From: [Rael, Rudy E.](#)
To: ["tecnm@yahoo.com"](mailto:tecnm@yahoo.com)
Cc: [Carrillo, Abiel X.](#)
Subject: 407 Mesilla St SE
Date: Wednesday, November 16, 2016 10:24:00 AM

Based upon the information provided in your submittal received 11/3/16, the above referenced Grading and Drainage plan dated 11/2/16 cannot be approved for Grading Permit or Building Permit until the following comments are addressed:

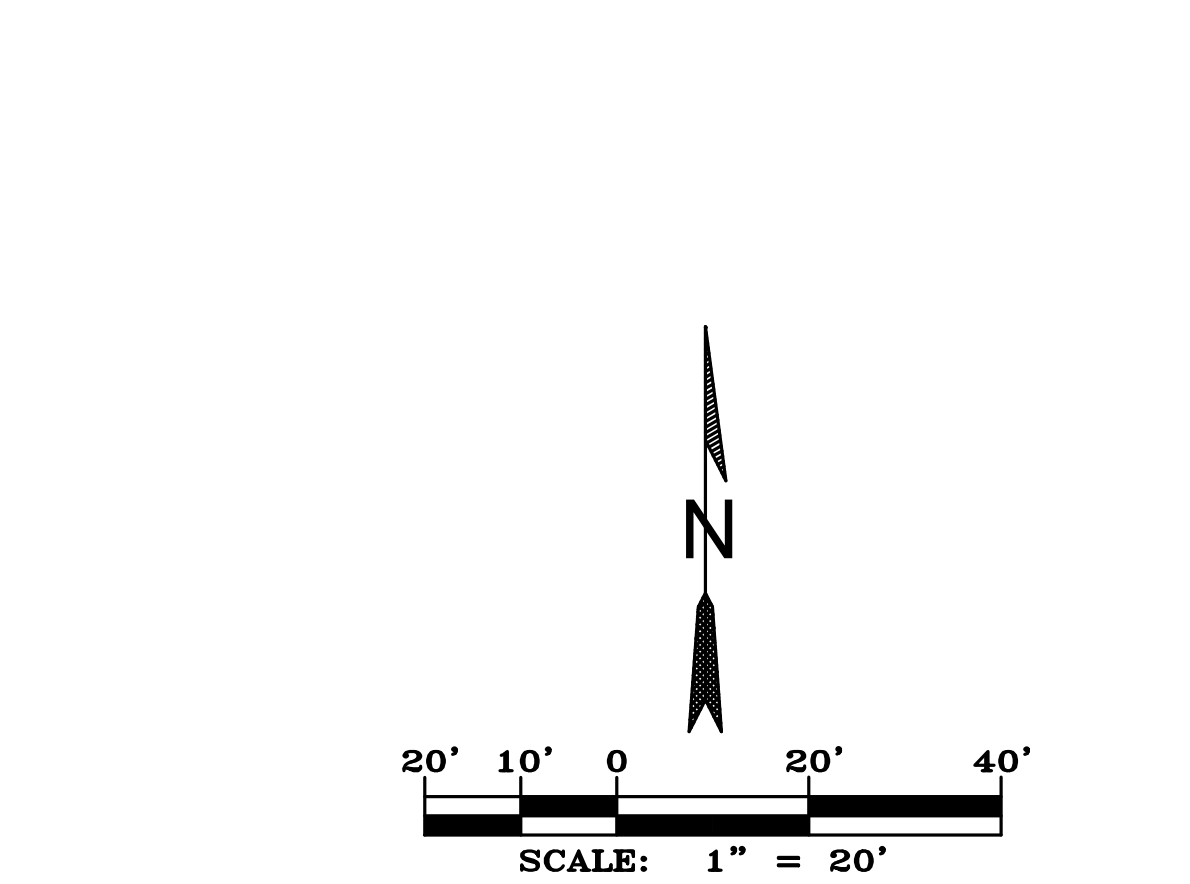
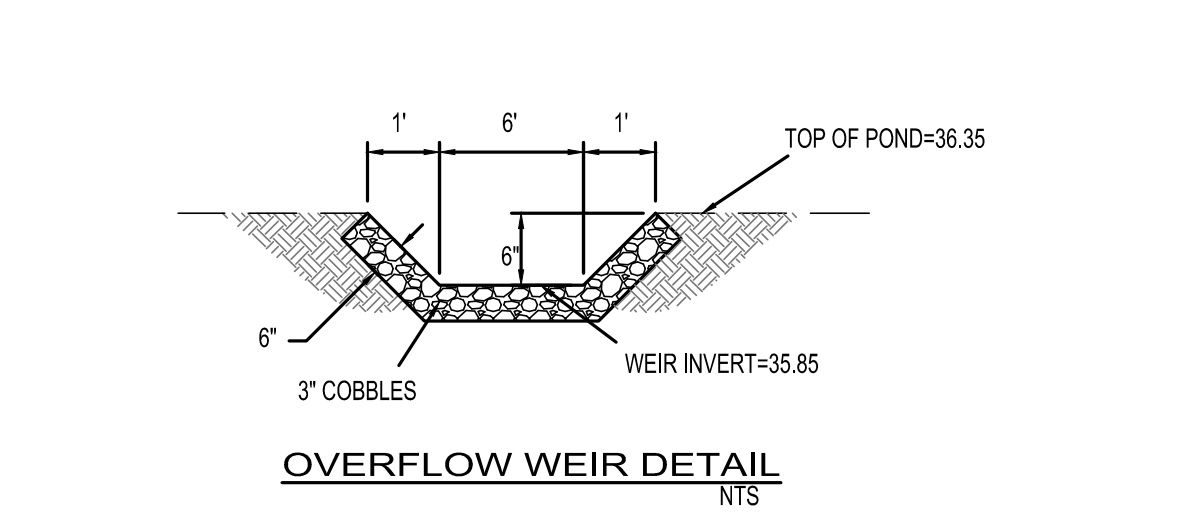
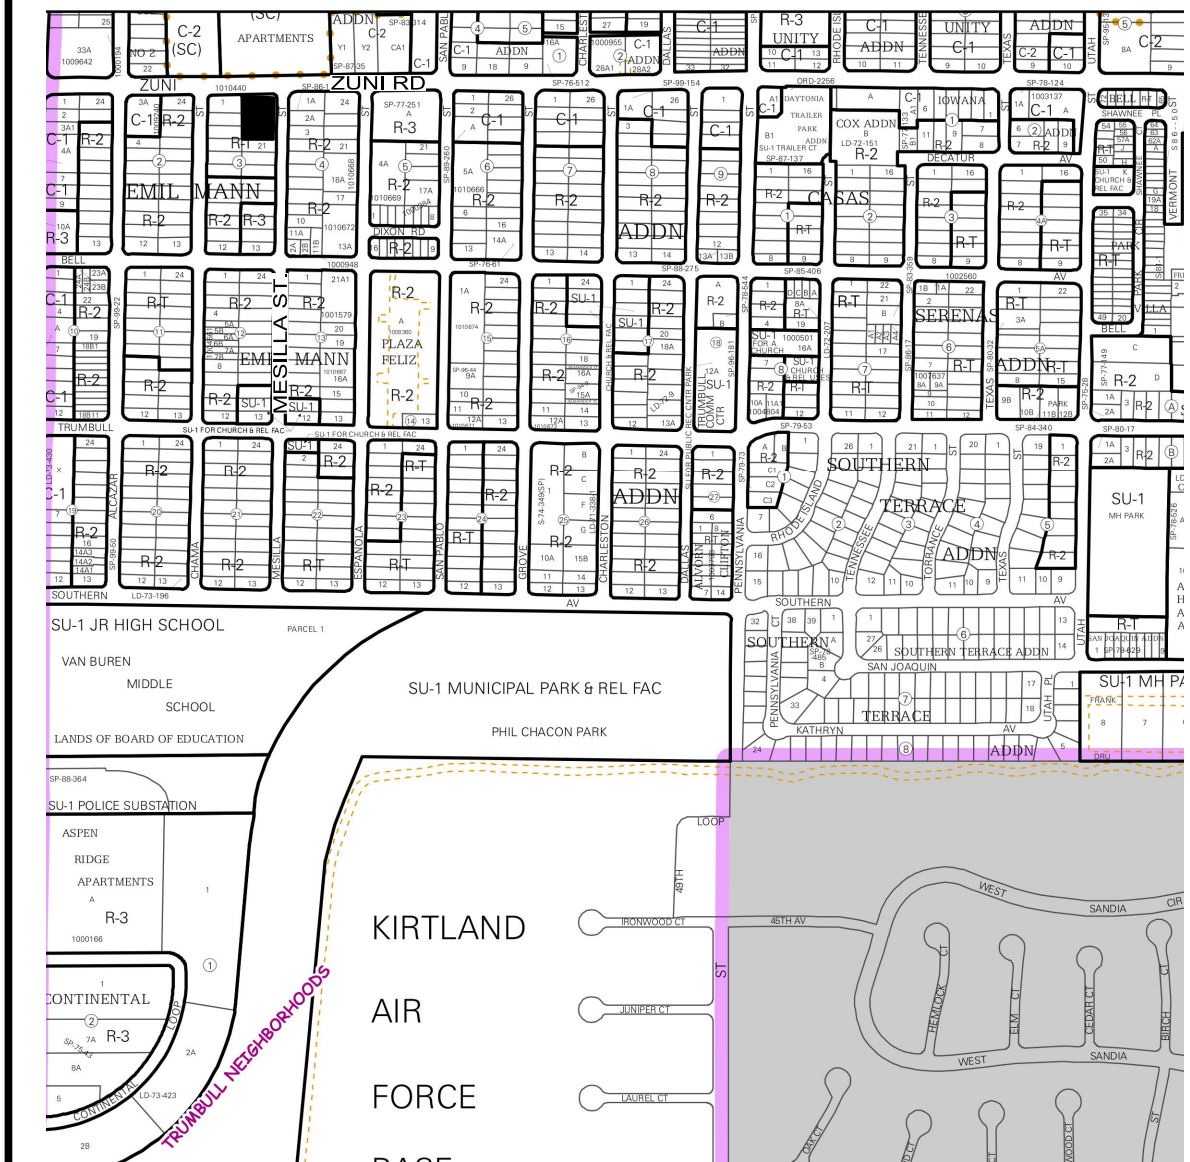
- Raise the weir by 4", enlarge the weir by 4' per our conversation on 11/16/16.
- Provide a detail of the swale.
- Provide a spot elevation on the sidewalk where the overflow from pond A to pond B is located.
- Provide a statement concerning any future fence must show an opening where the weir and the swale overflow.
